ATLASSIAN CENTRAL

Response to Submissions -
Heritage & Archaeology

Urbis has been commissioned by Atlassian (the Applicant) to prepare this report in response to the issues raised in by government agencies, community organisation groups and the public during the public exhibition of the proposed Atlassian Central State Significant Development (**SSD**) application (SSD-10405) in relation to the site at 8-10 Lee Street, Haymarket.

EAST ELEVATION

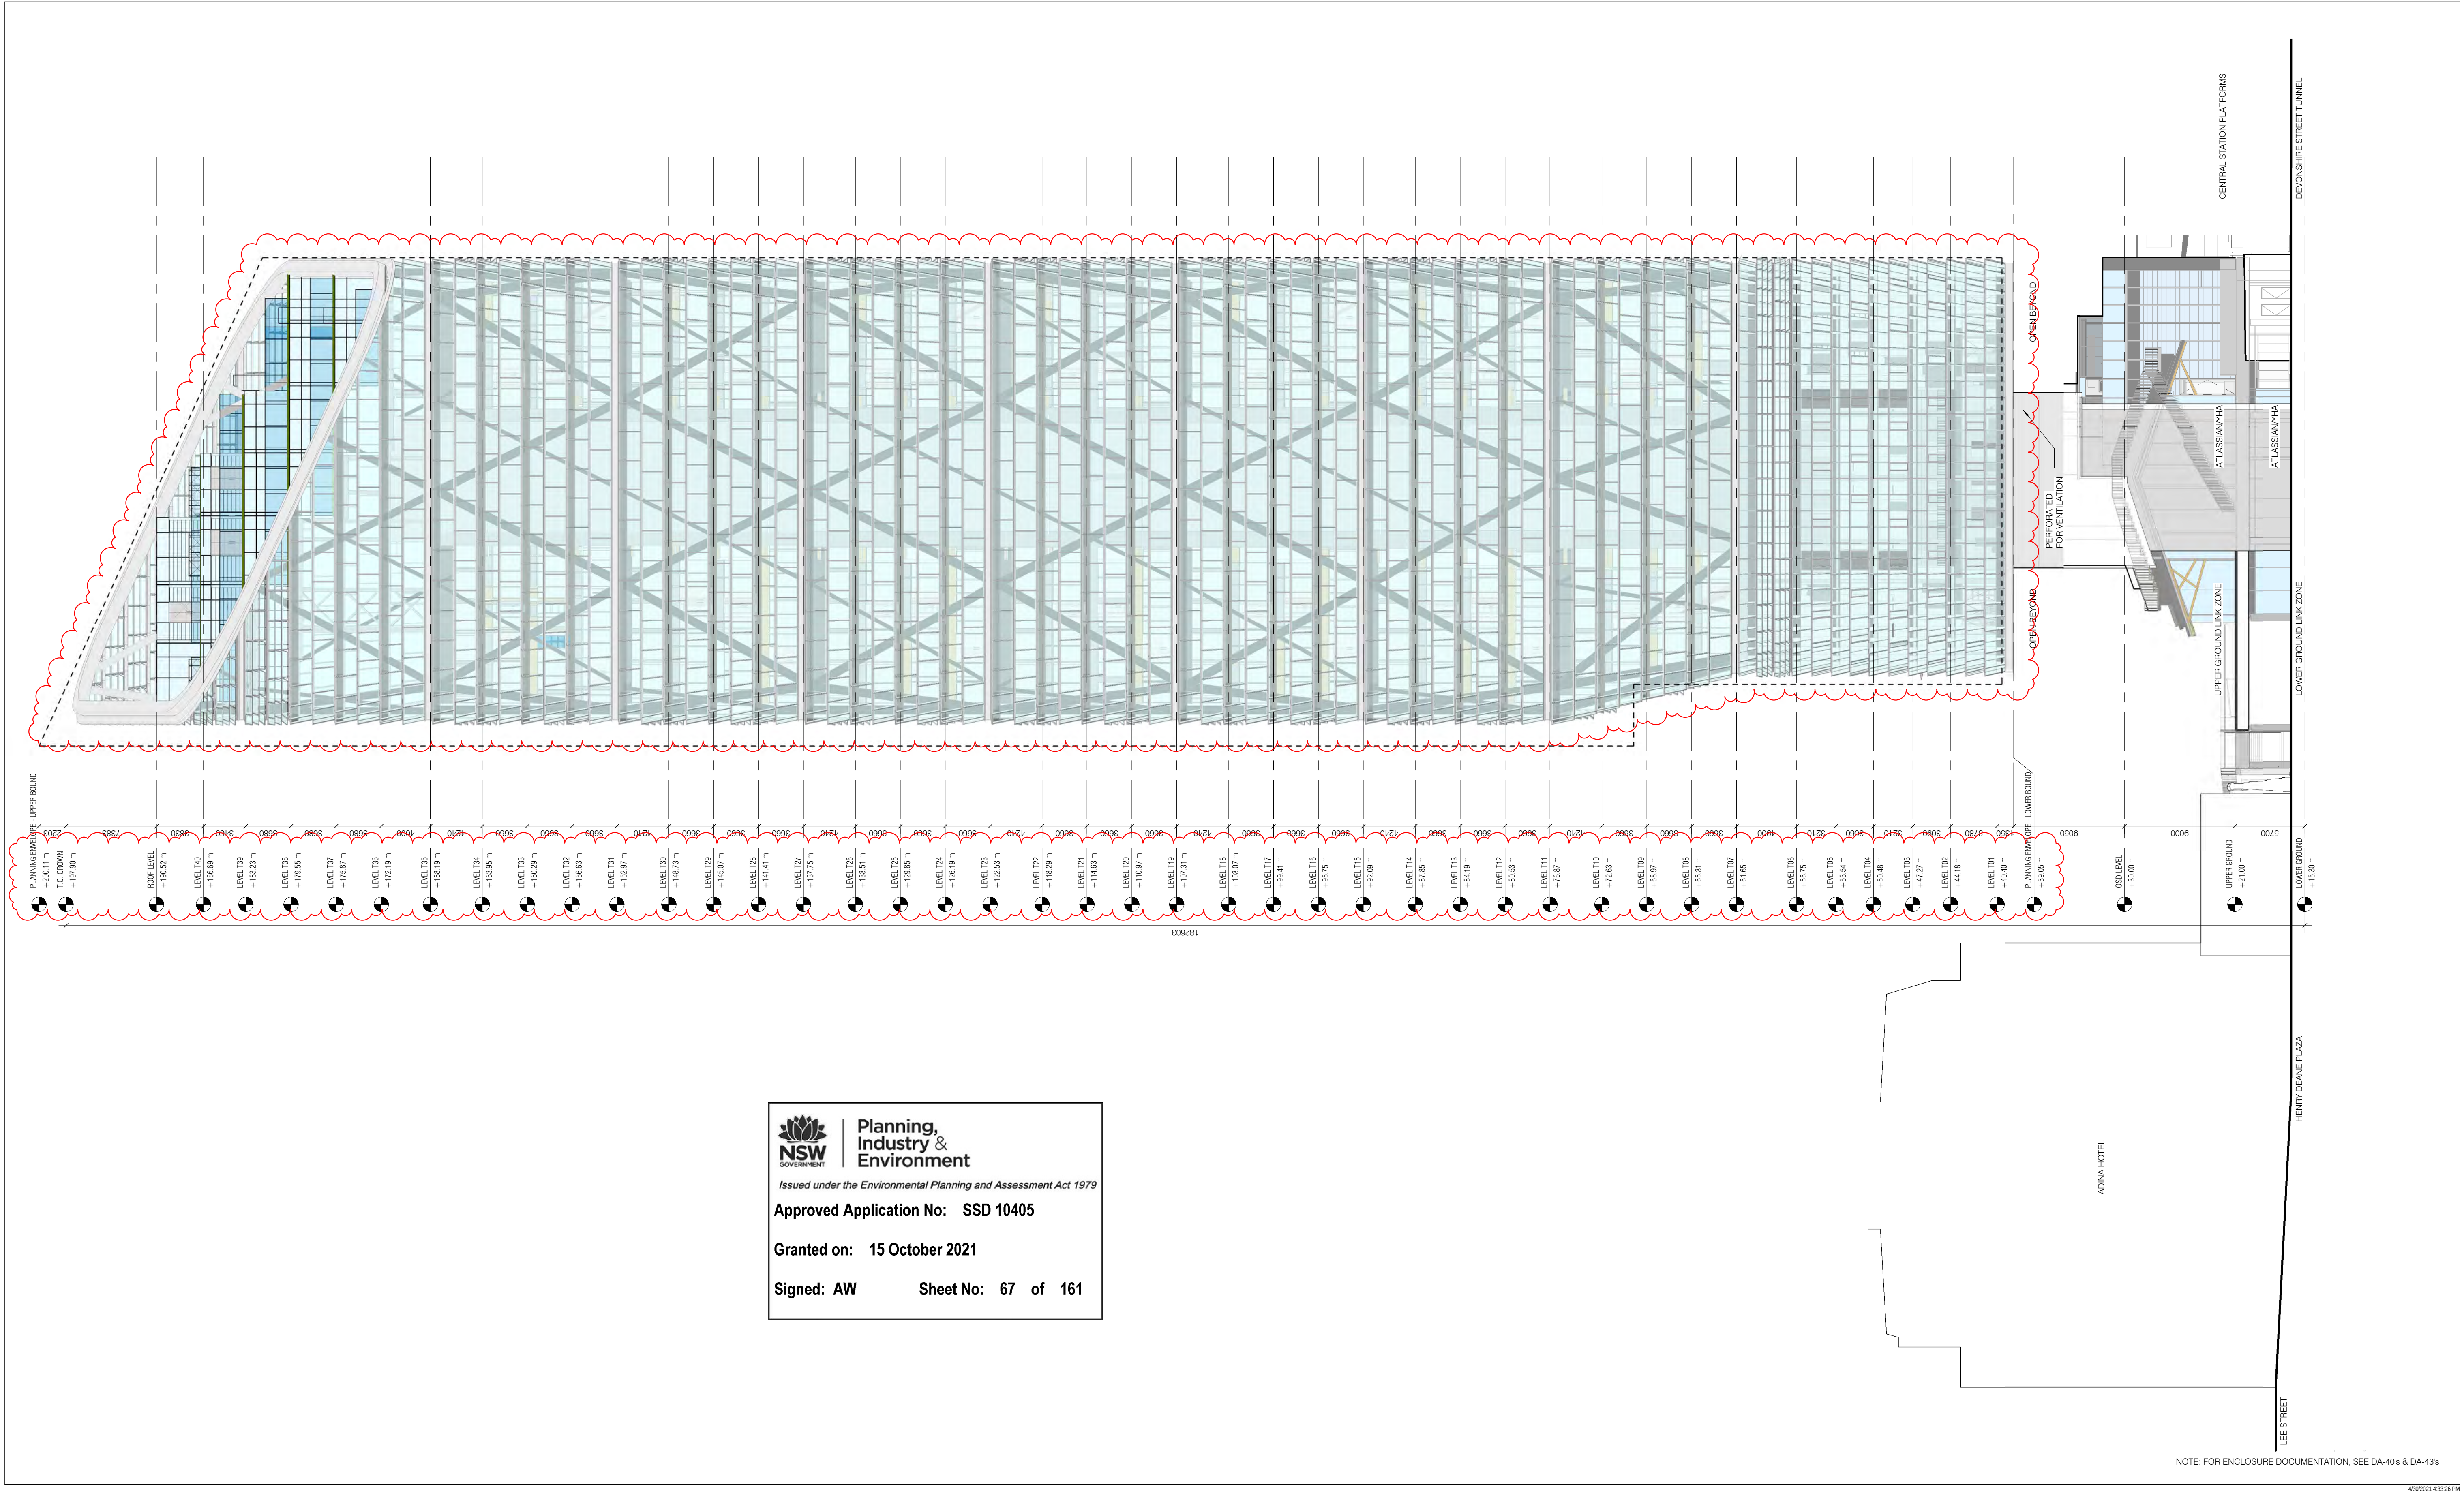
<p><i>The blank wall on the ground floor on the eastern elevation separating the train station does not deliver any connectivity or engagement between the new development and the station.</i></p> <p><i>The City understands this wall is essential for fire and blast separation between the rail line and the new building (e.g. if a diesel train derails at platform 1 or 2). Its scale and impact need to be ameliorated by modelling or sculpting the wall in three dimensions with piers or other architectural features and must have a design quality and materiality commensurate with the existing quality of Central Station. The wall could also be an opportunity for a public artwork.</i></p> <p><i>The importance of this wall appearance is high if these platforms are to be built over in future.</i></p>	<p>The Heritage Interpretation Strategy has developed a thematic structure in which some themes are specific to the Atlassian site, and others which are broader, shared by the greater precinct. Intersections is a theme with resonance to the entire site, with numerous stories to be interpreted.</p> <p>The eastern boundary wall, facing east, highly visible from the railway platforms, is a potential site offering opportunities to consider the theme of Intersections and ideal for commissioning a First Nations artist in response to both the location and the cultural heritage of the place.</p> <p>The following response is provided by Cox Inall Ridgeway:</p> <p><i>We understand that the significance of Platform 1 at Central Station to the Stolen Generation Survivors and their families is a key heritage consideration for TfNSW in the renewal of Central Precinct. We will work with</i></p>

WEST ELEVATION

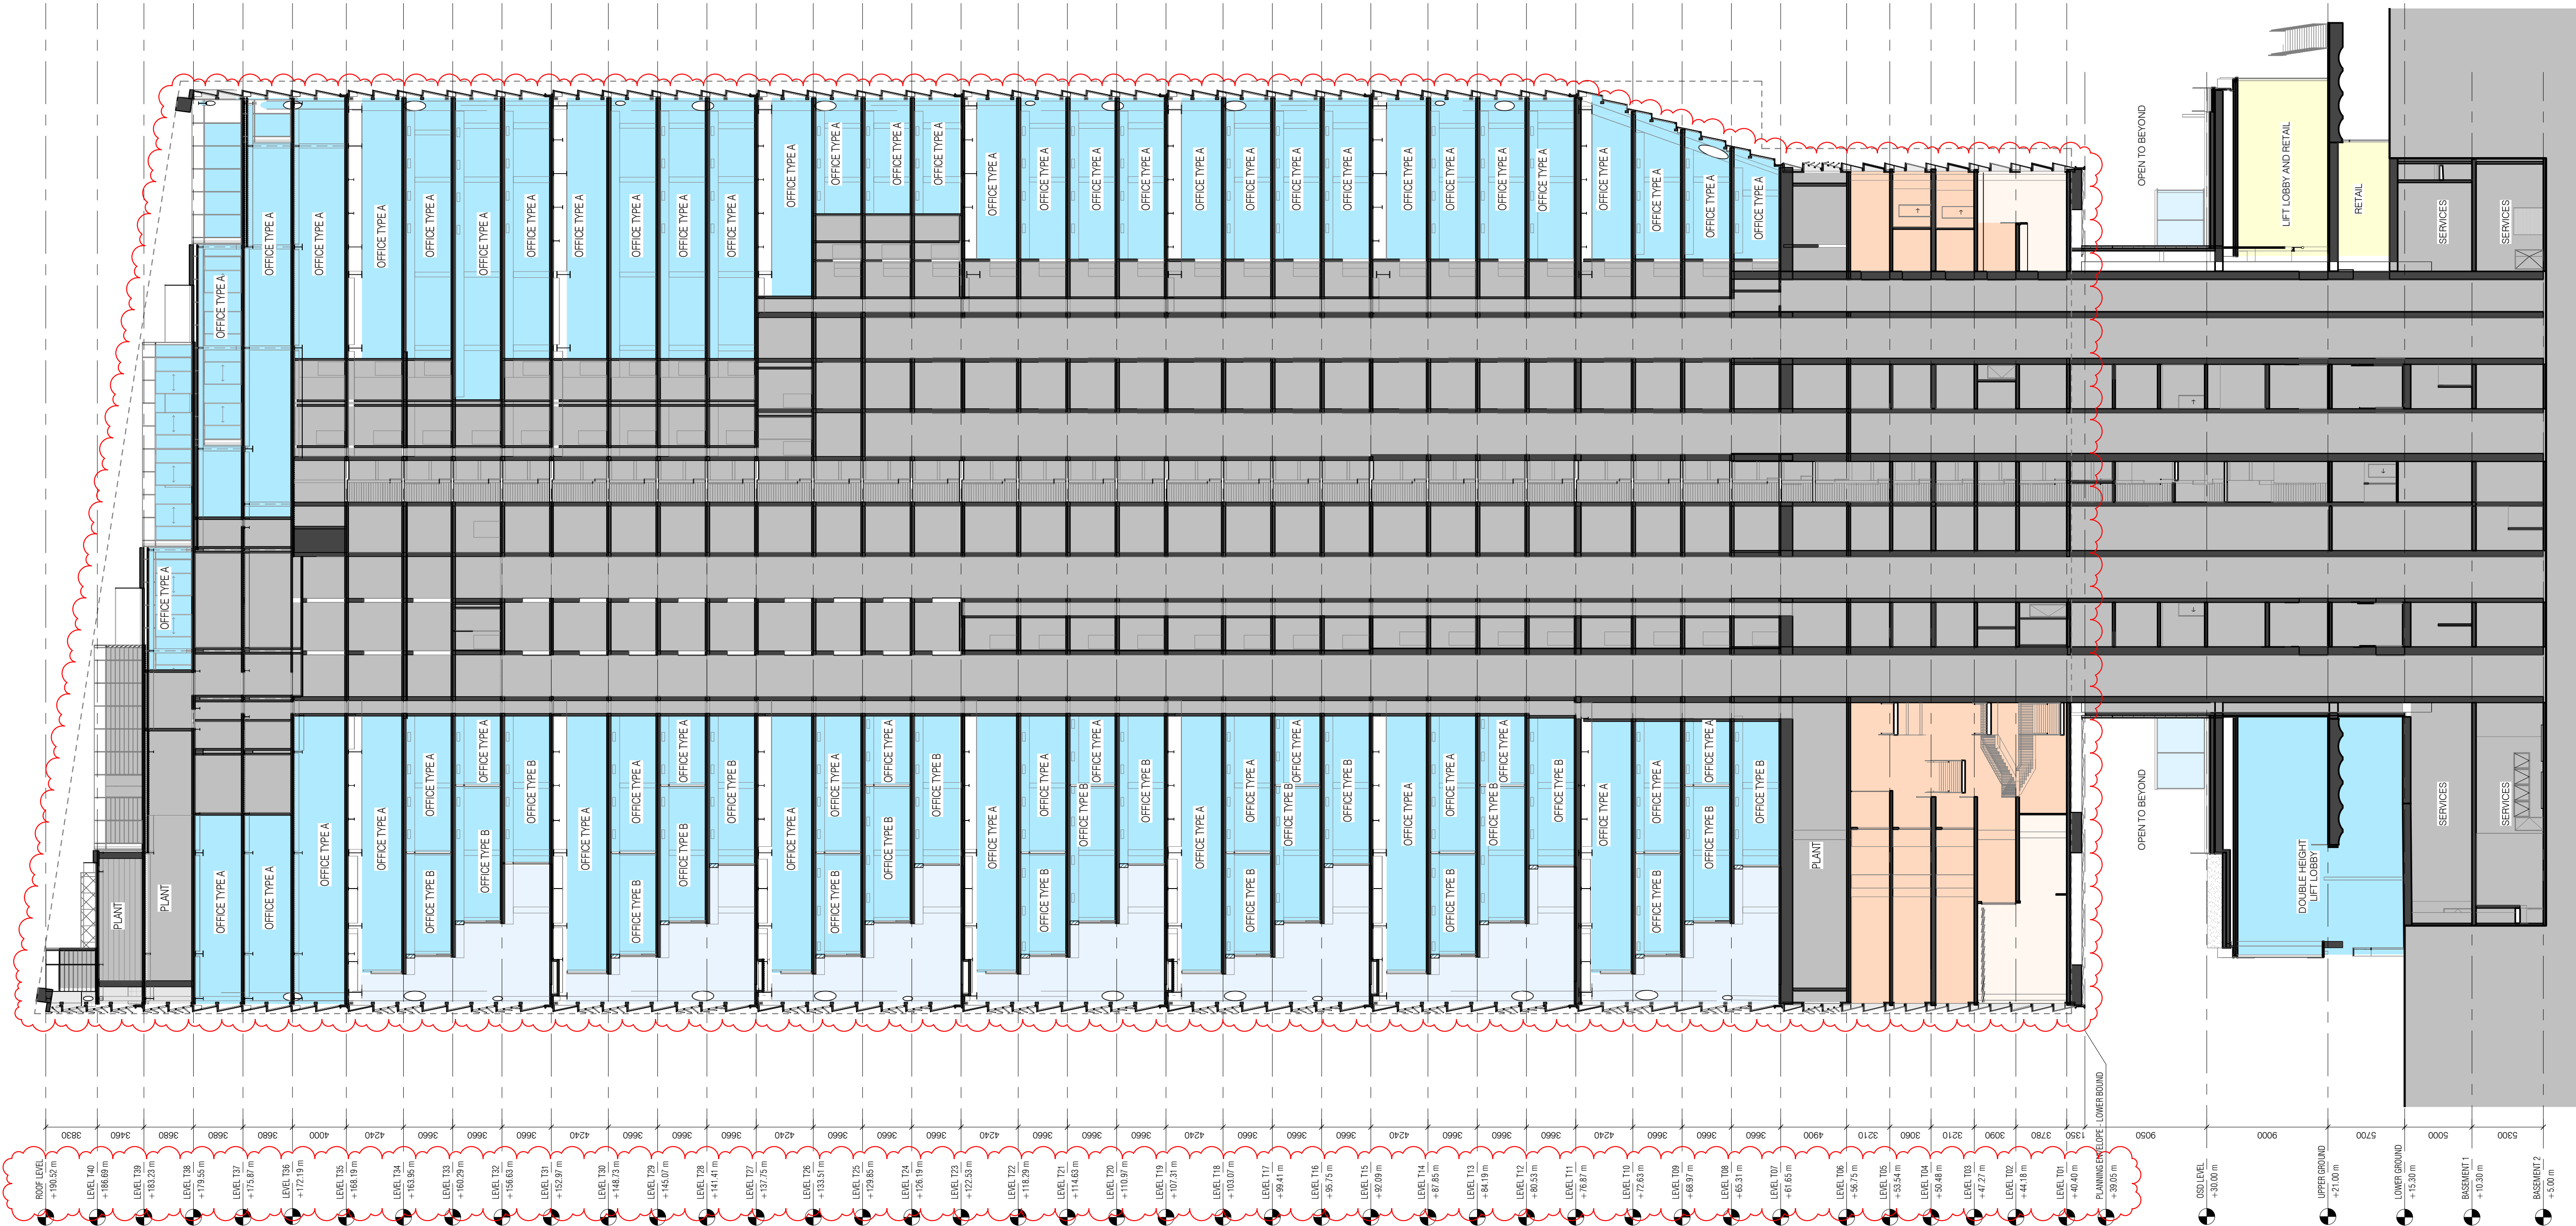
<p><i>The large amalgamated arch facing Ambulance Avenue needs more work and is considered to be out of scale and unsympathetic in the context. In its current form, it would result in a substantial loss of the fine and significant original brick masonry.</i></p> <p><i>This new access to the shopping concourse to the south should be delivered as three new arches within the existing brick pier set out. These need to be consistent with the scale, classical proportions, geometry, wall thickness and construction detailing of the existing brick arches in the wall. The proposed demolition of the existing brick wall must be preceded by accurate survey of the existing fabric including a point-cloud laser scan of the entire wall and an inventory of all elements to be salvaged including sandstone elements and metal work. The brick wall must be reconstructed to the same brick rod (i.e. mortar joint) set out of the retained east end of the wall (note that the beds and perpends in the existing brick wall are less than the modern standard of 10mm). All existing brick piers should be reconstructed to full height to match their original size, design and position. Please note that this was relayed to the applicant in preliminary discussions and was agreed in principle at the time.</i></p>	<p>Further information on this issue has been prepared by the engineers and architects for the proposal. We refer the reader to the additional information provided.</p> <p>From a heritage perspective, this proposed enlarged archway is considered to be acceptable as the Ambulance Avenue wall is already undergoing substantial change as part of the proposal. All efforts have been made to retain an understanding of the existing / original openings throughout the wall, however as the subject site and this proposed archway is being driven by a broader transport accessibility motive from Transport for NSW and the Government, this intervention is a necessary element to the overall enhanced Central Station precinct. We are comfortable that the original confirmation of the openings can be understood through careful interpretation and a refined approach to the reconstruction of this wall to clearly delineate between old and new.</p>
